Our ref: WA/2018/125672/01-L01
Your ref: 18/01363/F
Date: 12 September 2018

Improvement of community facilities compromising construction of disabled toilet, garage for community minibus, bi-fold door and patio.

Wendlebury Village Hall Main Street, Wendlebury, Oxfordshire, OX25 2PS.

# PROPOSED BUS GARAGE

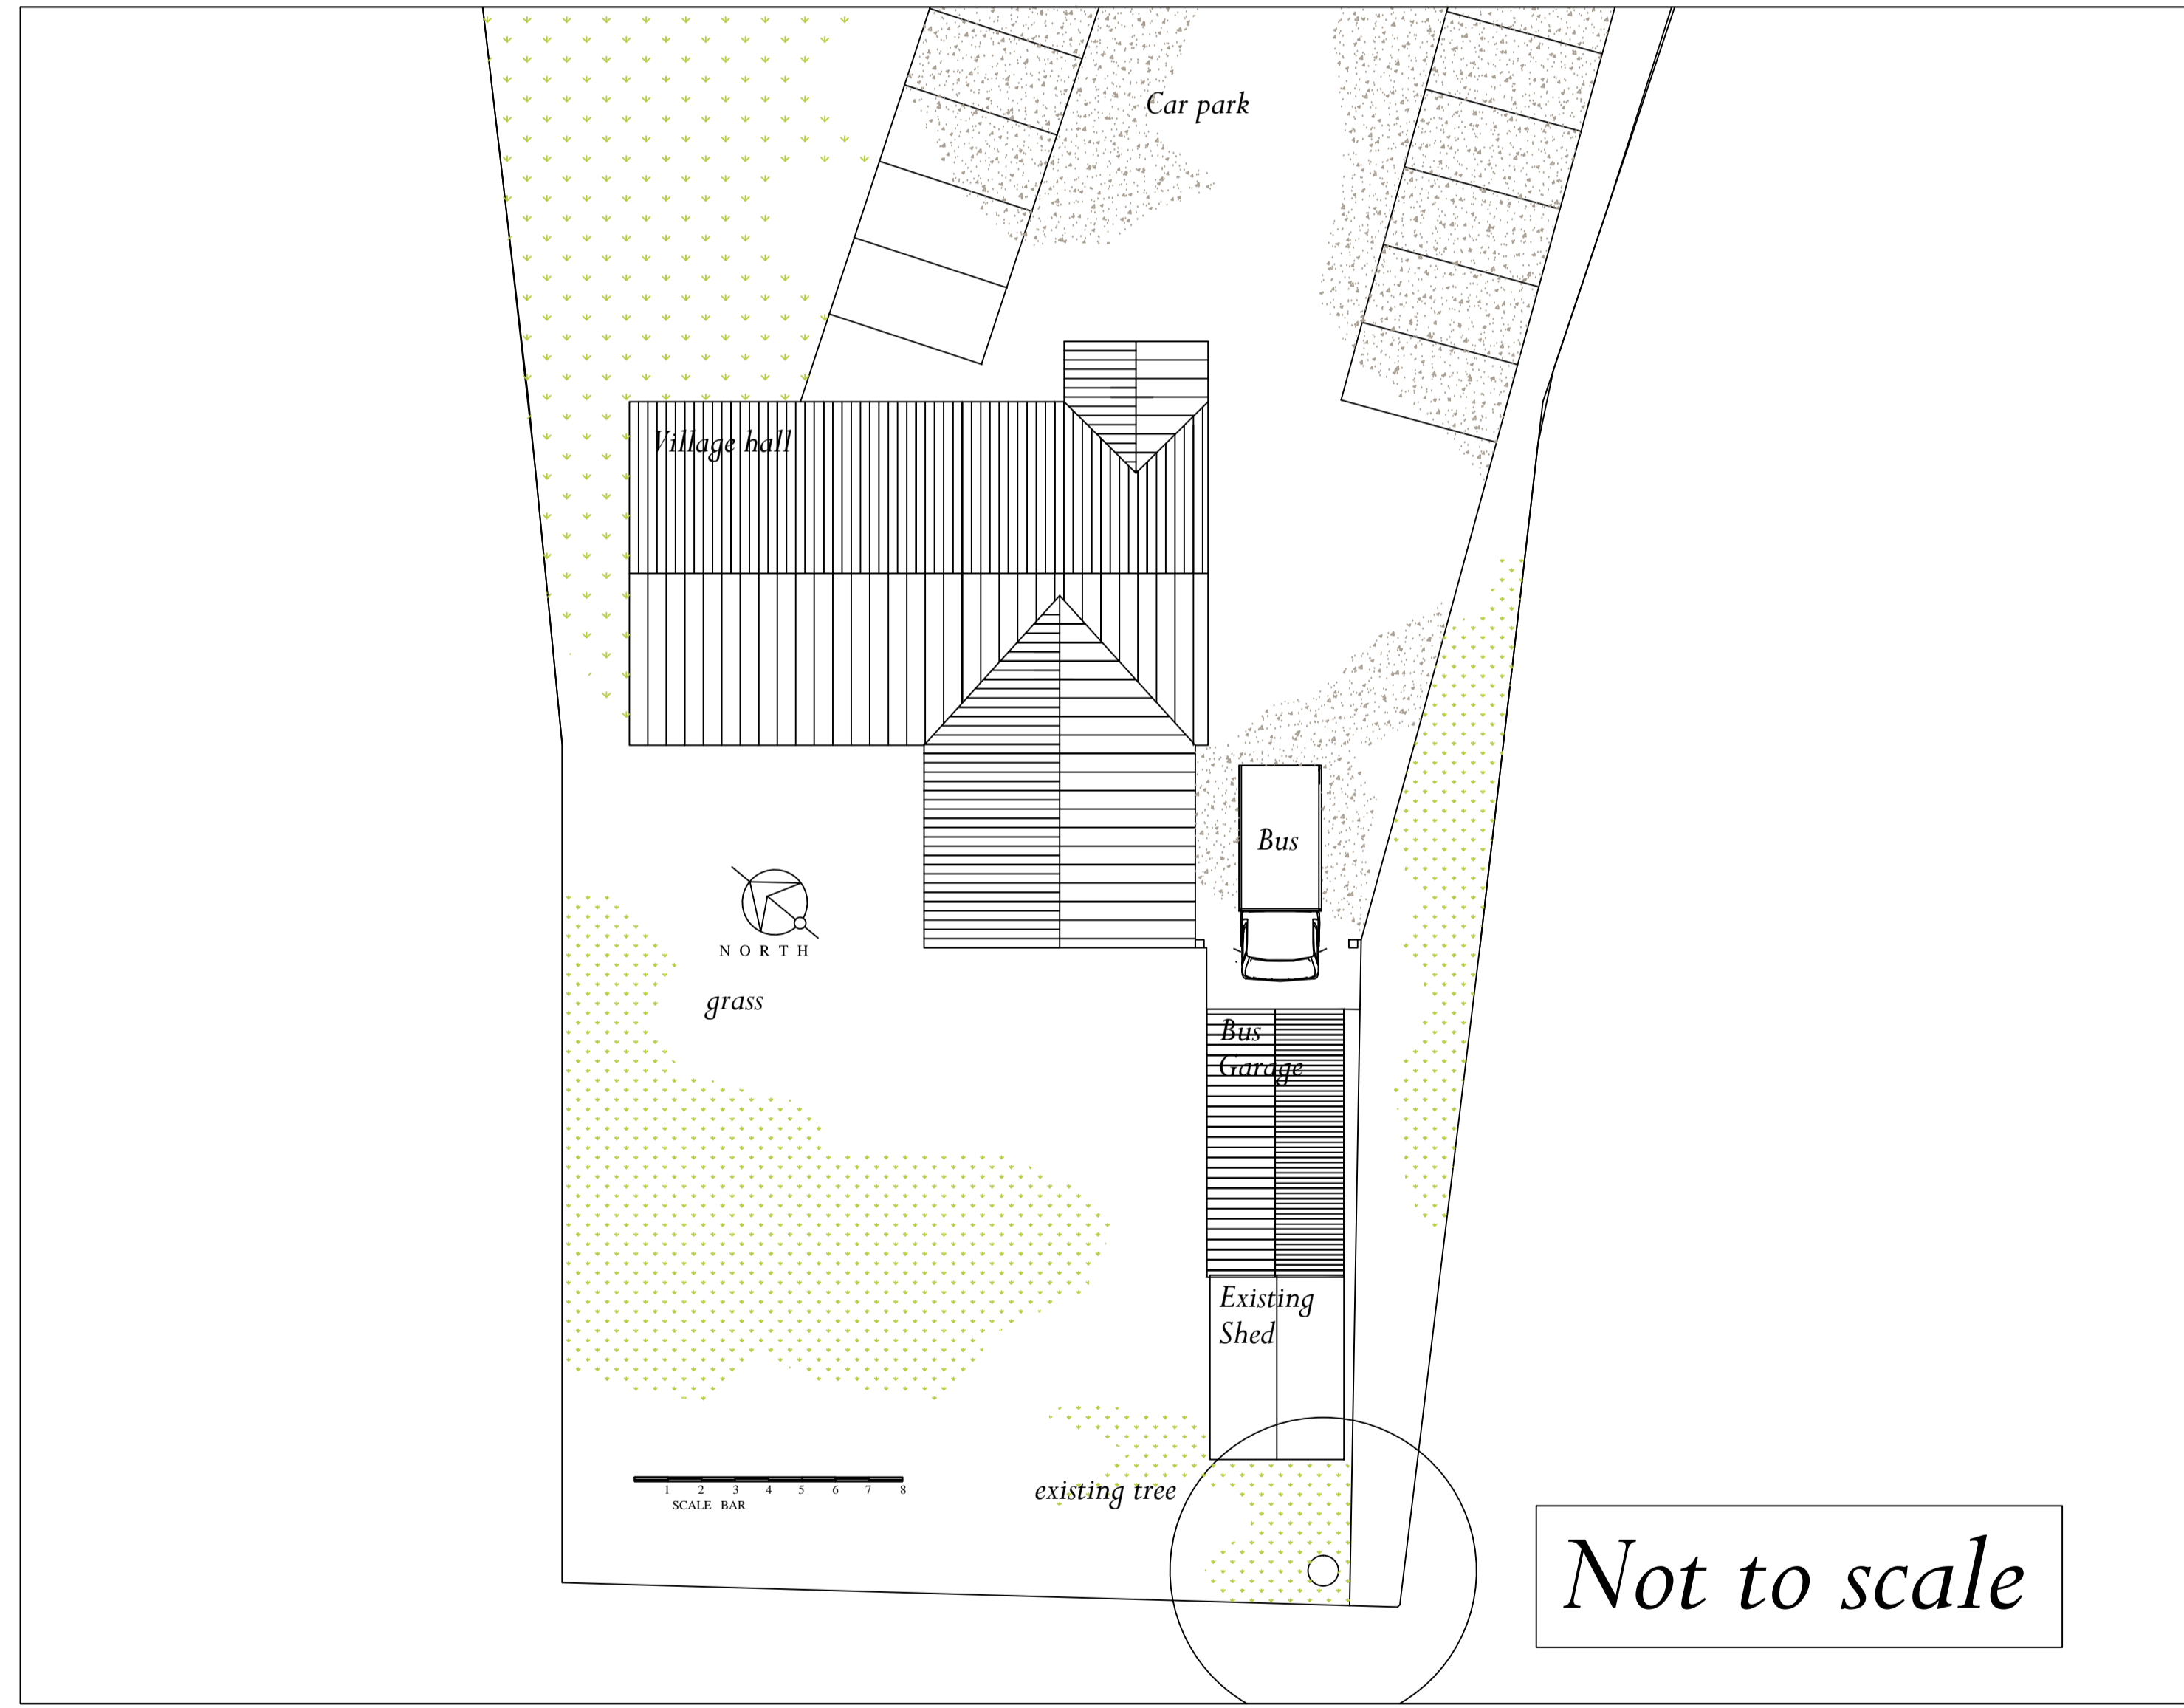
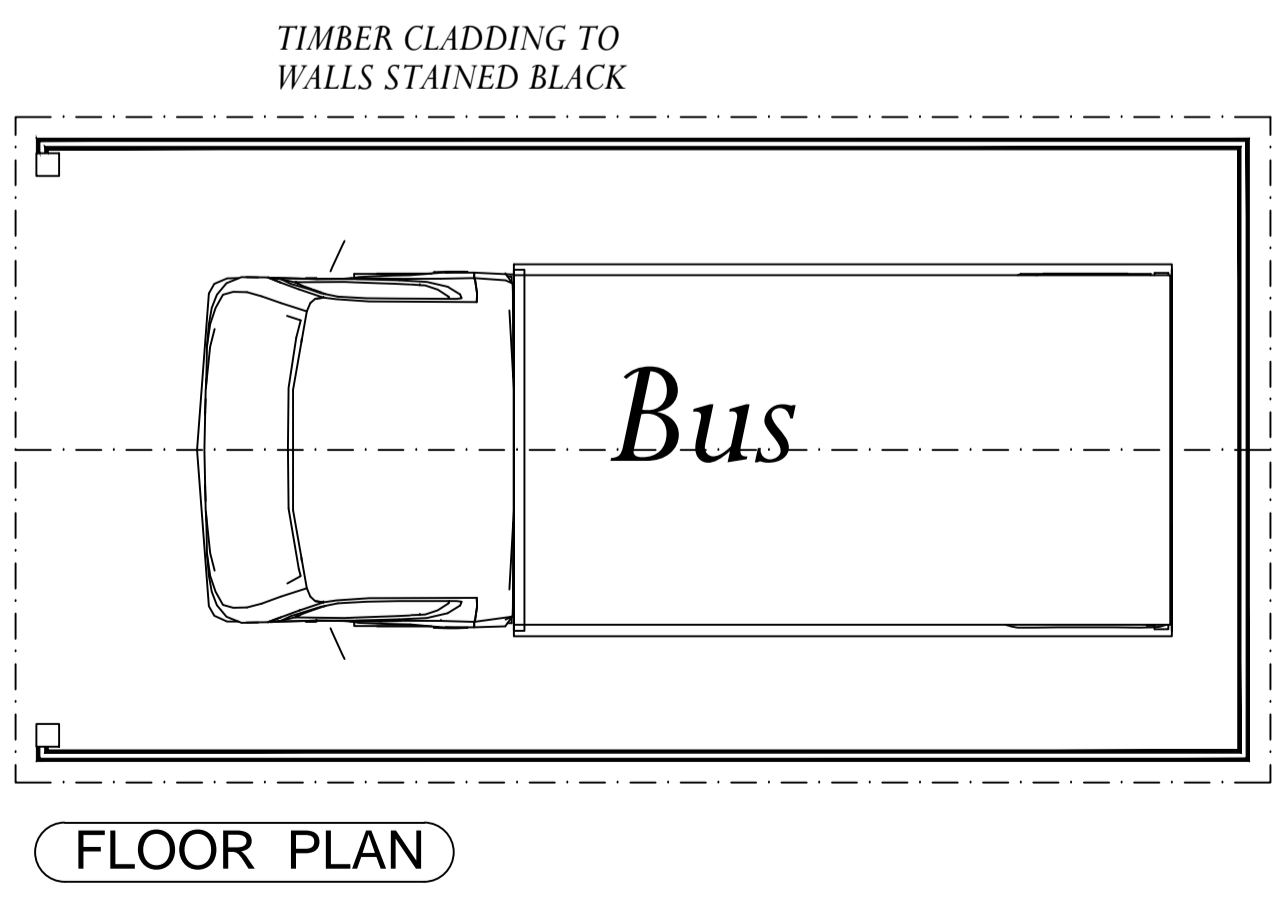
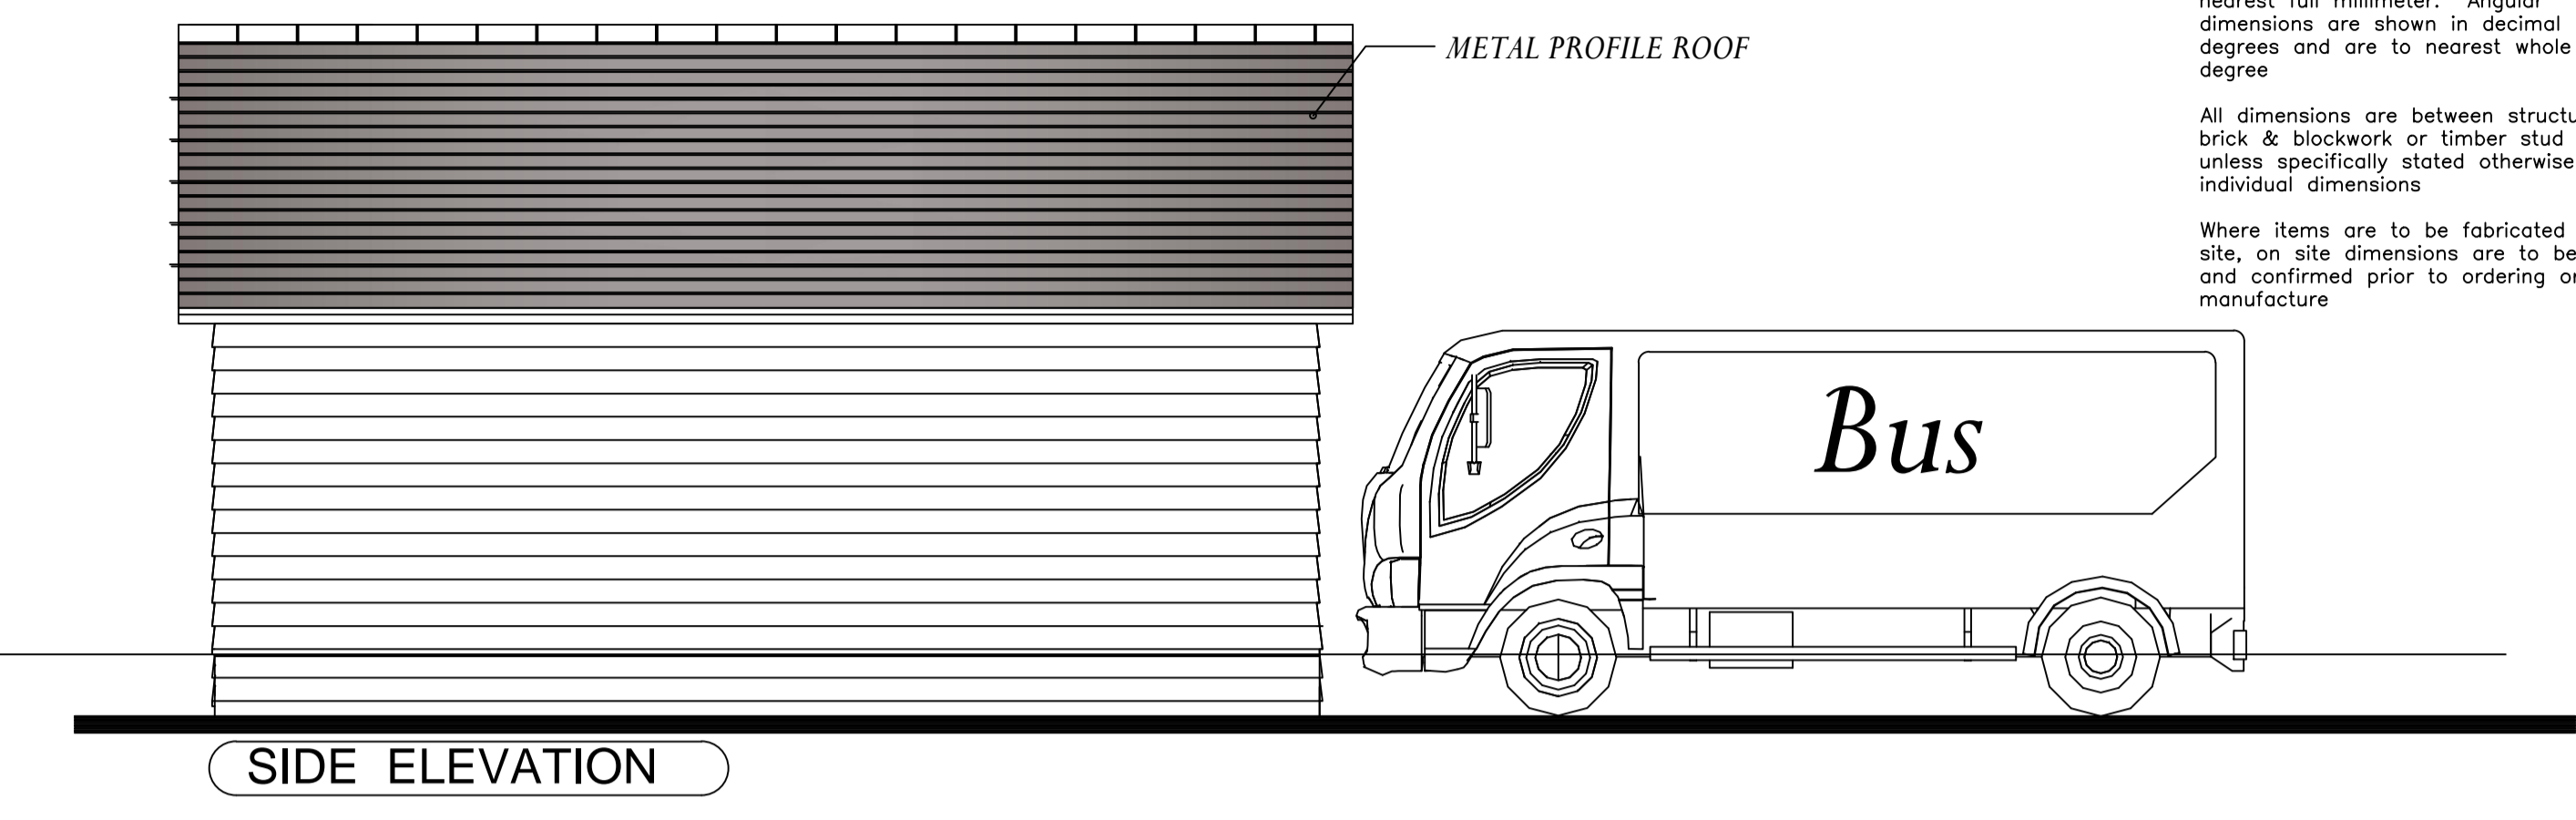
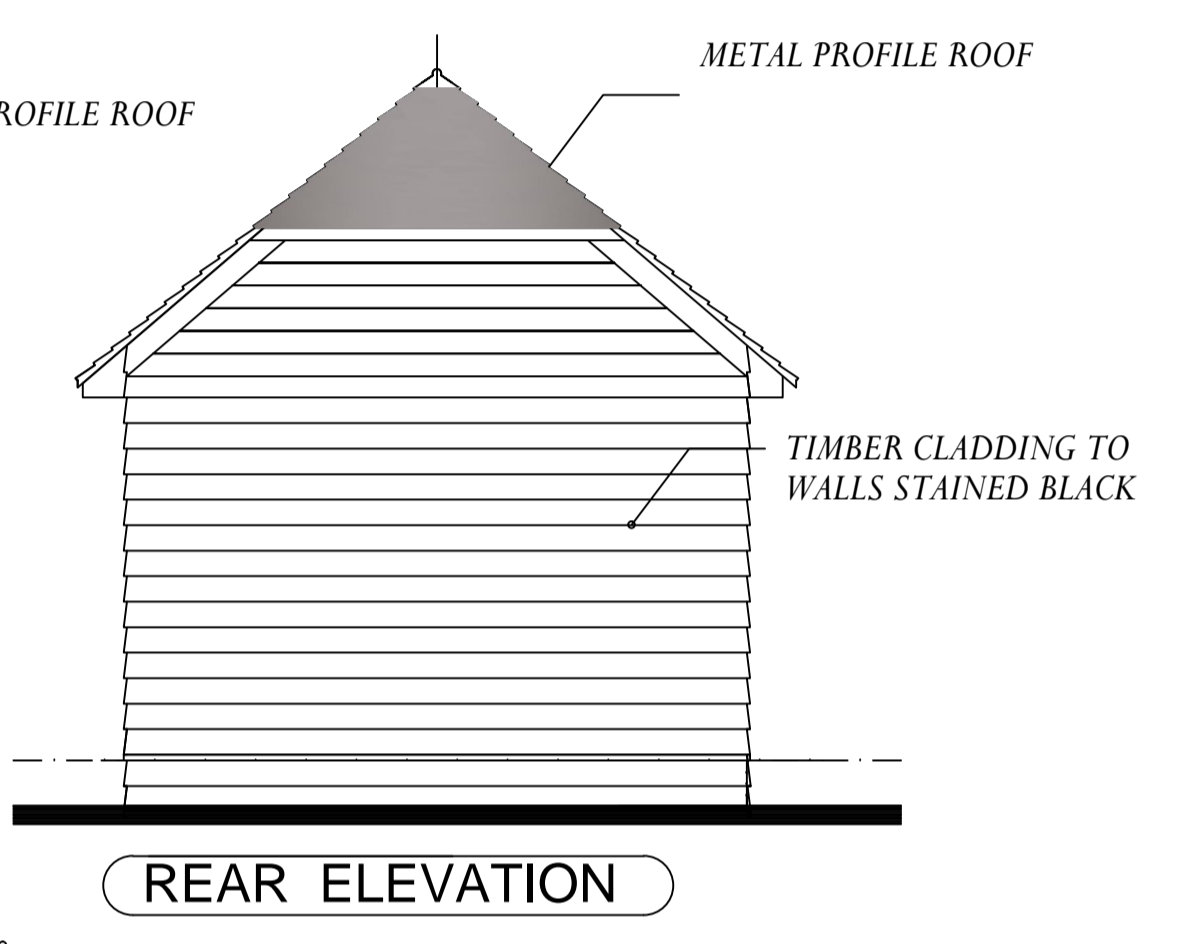
The application seeks approval to construct an extension to incorporate a disabled toilet, replacement of windows and small patio area and construction of a garage to house the Wendlebury Community Minibus. The proposed garage will increase the built footprint on site by 33sqm.

The proposed garaged is potentially located within the 1 in 100 flood extent with appropriate allowance for climate change, and therefore would need to be mitigated. The applicant should demonstrate whether the proposed garage is within the 1 in 100 flood extent or not.

The applicant should demonstrate that raised finished floor levels for the proposed development are set above the 1% annual probability (1 in 100) flood level with an appropriate allowance for climate change. This will reduce the risk of flooding to people and property.

The applicant can overcome our objection by submitting an FRA which covers the deficiencies highlighted above and demonstrates that the development will not increase flood risk elsewhere and where possible reduces flood risk overall. If this cannot be achieved we are likely to maintain our objection to the application.

Specifically, the FRA will need to demonstrate that any increase in built footprint within the 1% annual probability (1 in 100) flood extent with an appropriate allowance for climate change can be directly compensated for. This is necessary to prevent the new development reducing flood plain storage and displacing flood waters, thereby increasing flood risk elsewhere.
